Online Comment

Application H16-1150-25
Location 7-9 Pinchbeck Road Spalding Lincolnshire PE11 1QD
Proposal Change of use from 2 flats to 8 bedroom HMO

Name Pedals c/o R J Smith
Address 18 Cley Hall Drive Spalding PE11 2EB

Ground and First Floor Block Plan

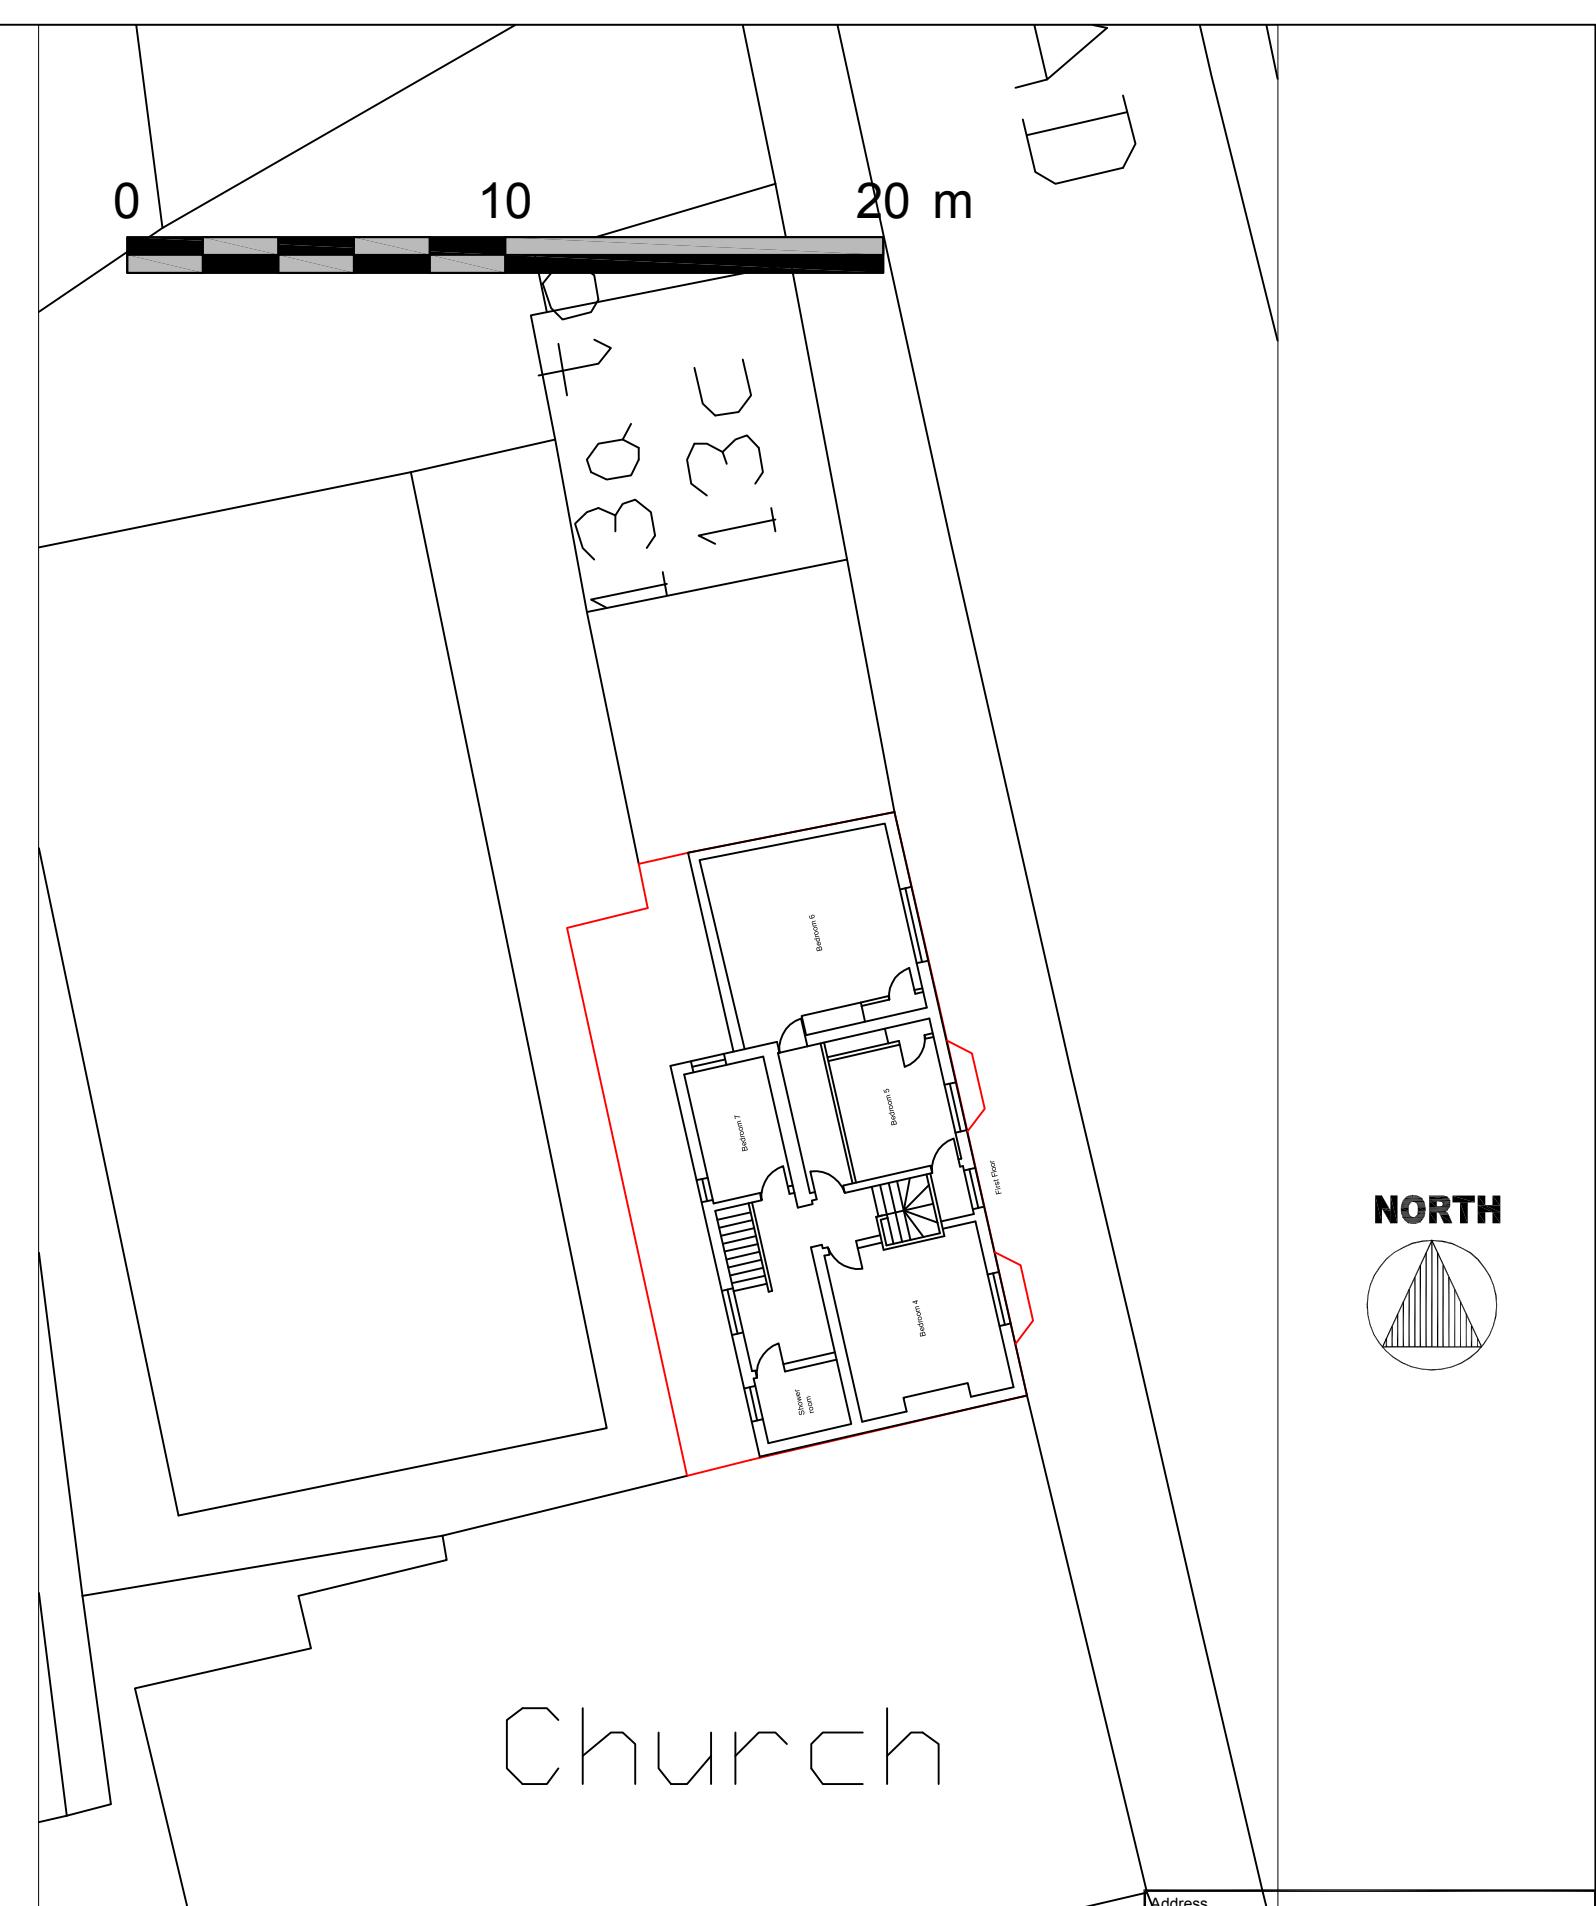
The cycle stands should be covered to protect the cycles from adverse weather, as specified in the "Think of Cycling" checklist published on the SHDC website. If permission is granted, please impose conditions which require details of the cycle store to be submitted to and approved by the Council before the development begins, and the approved details to be implemented and available for use before the development is occupied.
